**61 Mobbs Lane, Epping (former Channel 7 site) – Buildings 4 and 5,
Buildings 4 and 5 (MP08_0257 MOD 3)
Buildings 7 and 8 (MP10_0158 MOD 1)**

Description of Modification Requests

- MOD 3 – Strata subdivision – staged development
- MOD 1 – Strata subdivision

Director-General's
Environmental Assessment Report
Section 75W of the
Environmental Planning and Assessment Act 1979

CARPARK LEVEL 2

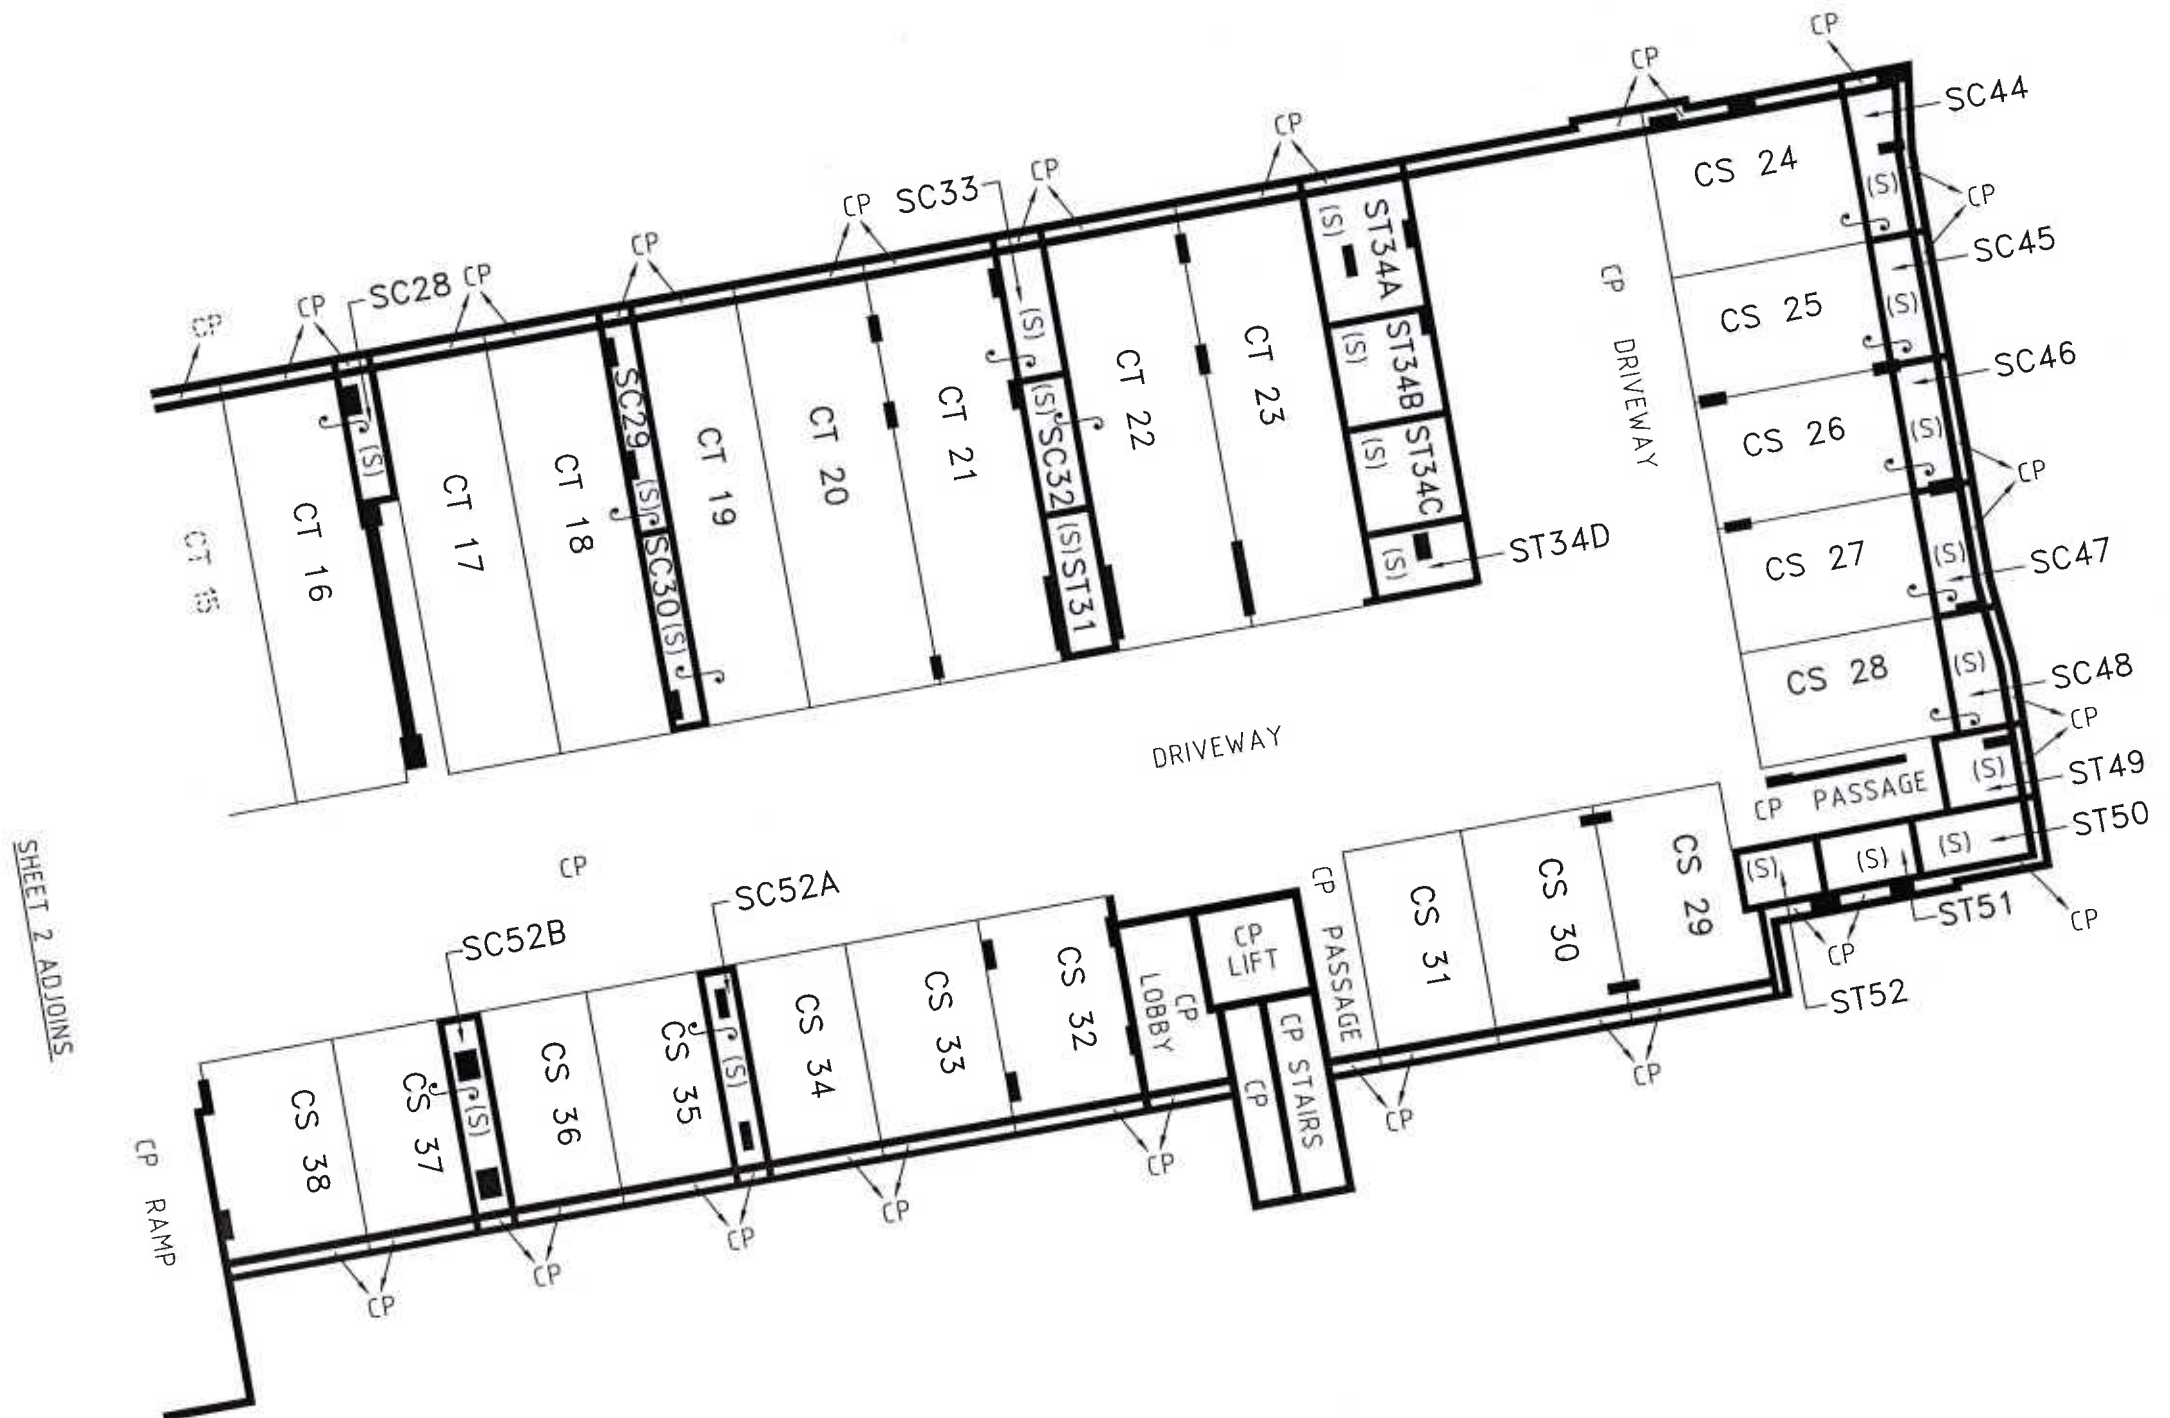
The strata plans (sheets 2-6) illustrate 201 basement car parking spaces which are consistent with the approved plans. The 23 visitor spaces are not shown on the strata plans as they are outside of the site. Meriton has confirmed that the road reserves around buildings 4 and 5 will be Lot 1 or association property within a community subdivision.

CARPARK LEVEL 1

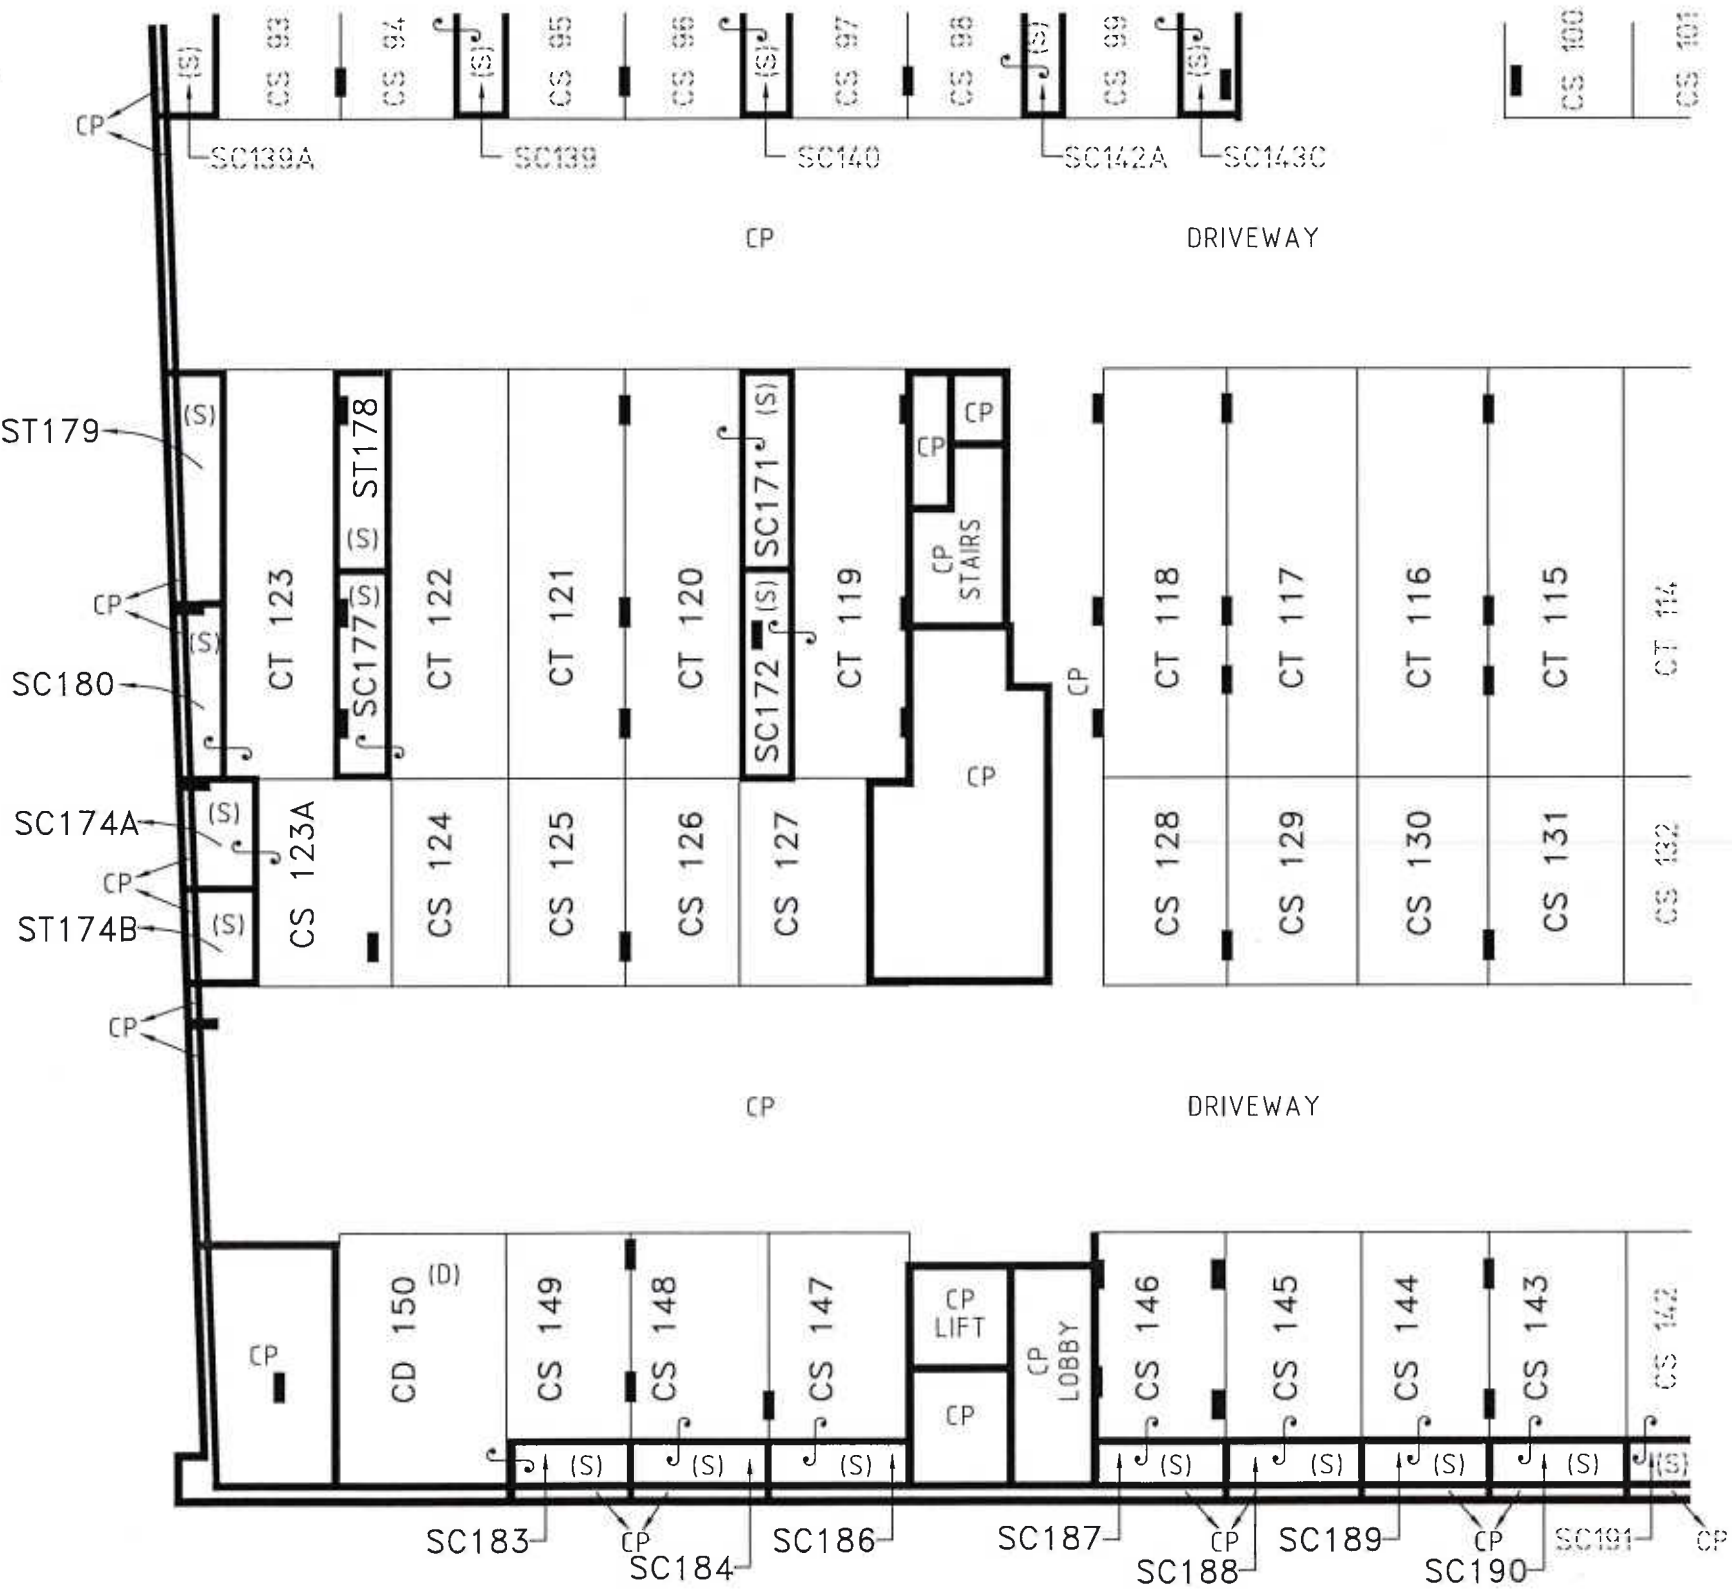
The strata plans (sheets 2-6) illustrate 173 basement car parking spaces which are consistent with the approved plans. The 13 spaces for persons with a disability are also consistent with the approved plans. The 17 visitor spaces in the basement are not shown as common property on the strata plans and so the department will impose a condition requiring these spaces to be notated as common property prior to the issue of a Strata Certificate.

The department notes that while the car parking spaces are consistent with the approved plans, the entry and exit of the basement car park as shown on Strata Plan Sheet No.4 been shifted from the approved south-west corner of level 1 to the north-west corner of level 1. While both corners are illustrated as common property, the department considers changes to the entry and exit are inconsistent with the approved plans (Drawing A0011 & A8101).

Although it is a requirement of the Certifying Authority to ensure the approved plans are consistent with the strata plans prior to the issue of a Strata Certificate, the department will nevertheless impose a condition requiring Strata Plan Sheet 4 to be amended to reflect the approved car park entrance and entrance as shown on the approved plans. This will need to be submitted to the Director-General and certifying authority prior to the issue of a Strata Certificate.

BUILDING '4'
LEVEL 1

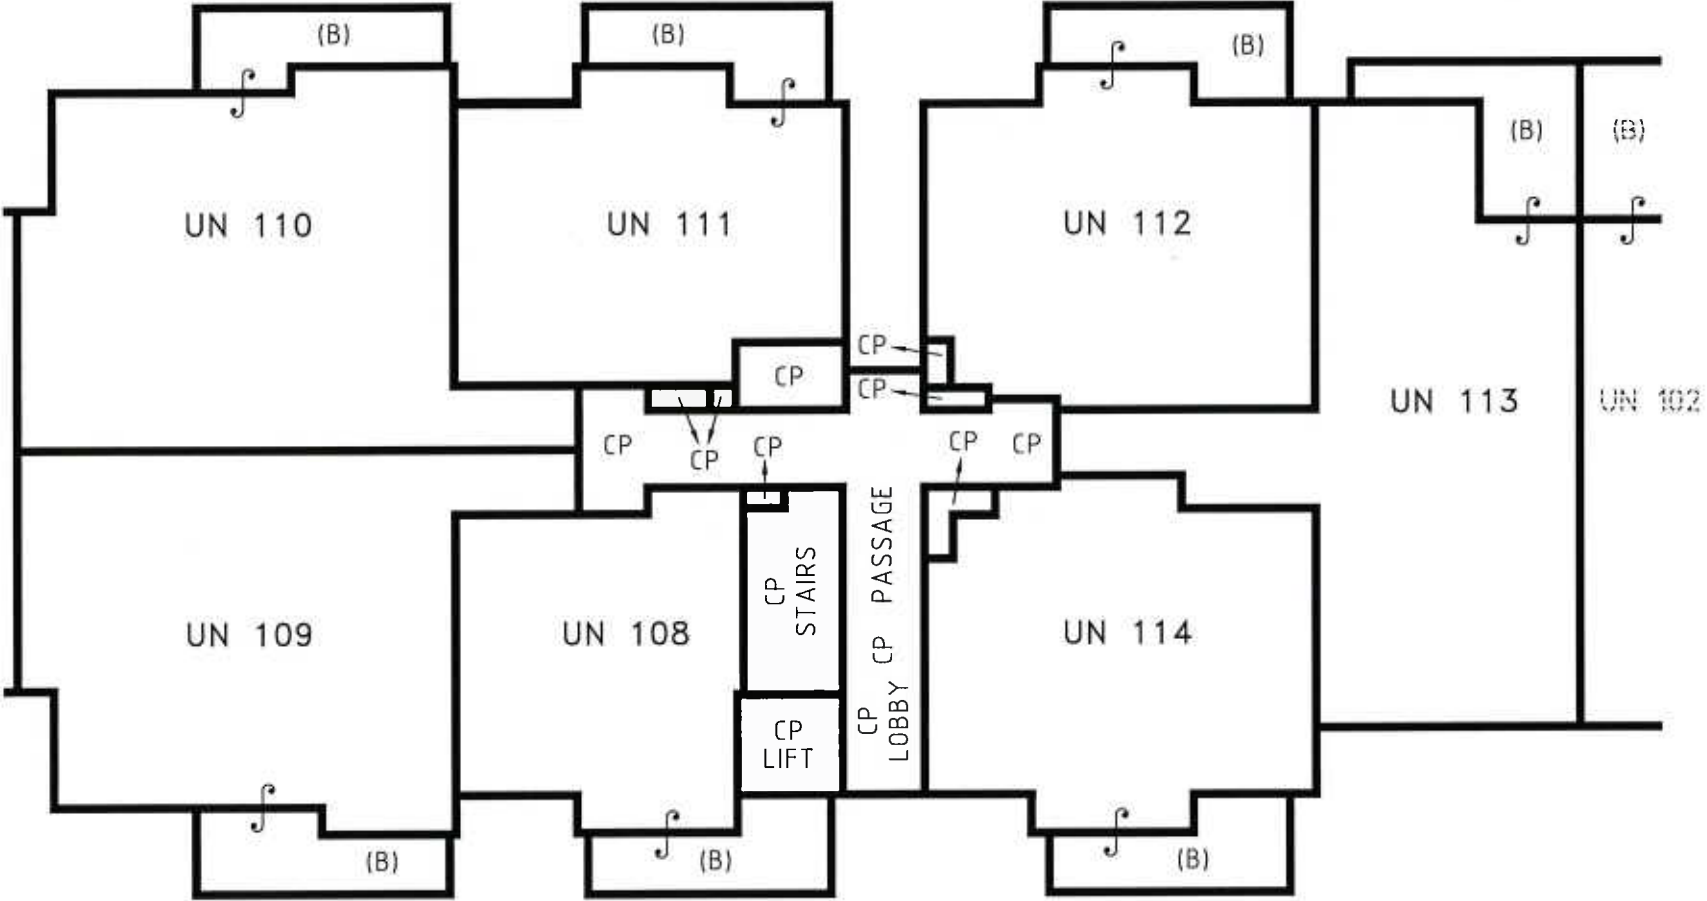
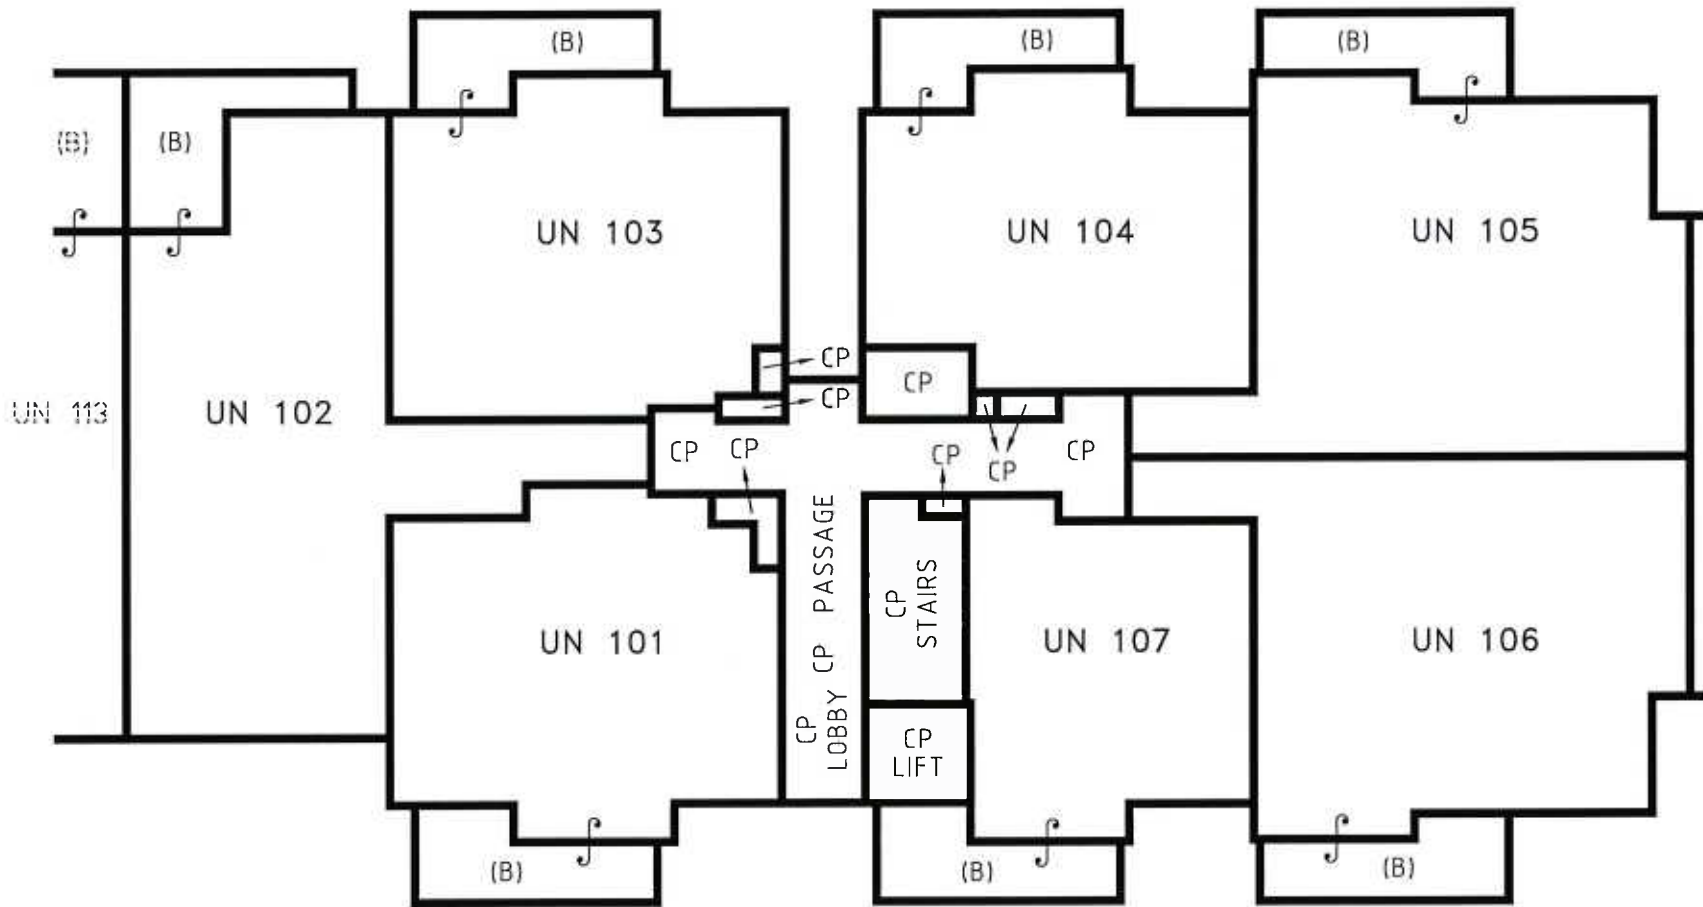
The proposed strata subdivision of the buildings will result in development that is substantially the same as the original approved developments. A comparison of the approved plans and strata plans is found at **Figures 8 –13**.

The department has reviewed the MOD 3 and MOD 1 strata plans and considers them to be generally consistent with the approved plans. On this basis, the proposed strata subdivision of buildings 4 and 5, staged subdivision of buildings 7 and 8 (MOD 3), and strata subdivision of buildings 7 and 8 (MOD 1) is considered appropriate and is supported.
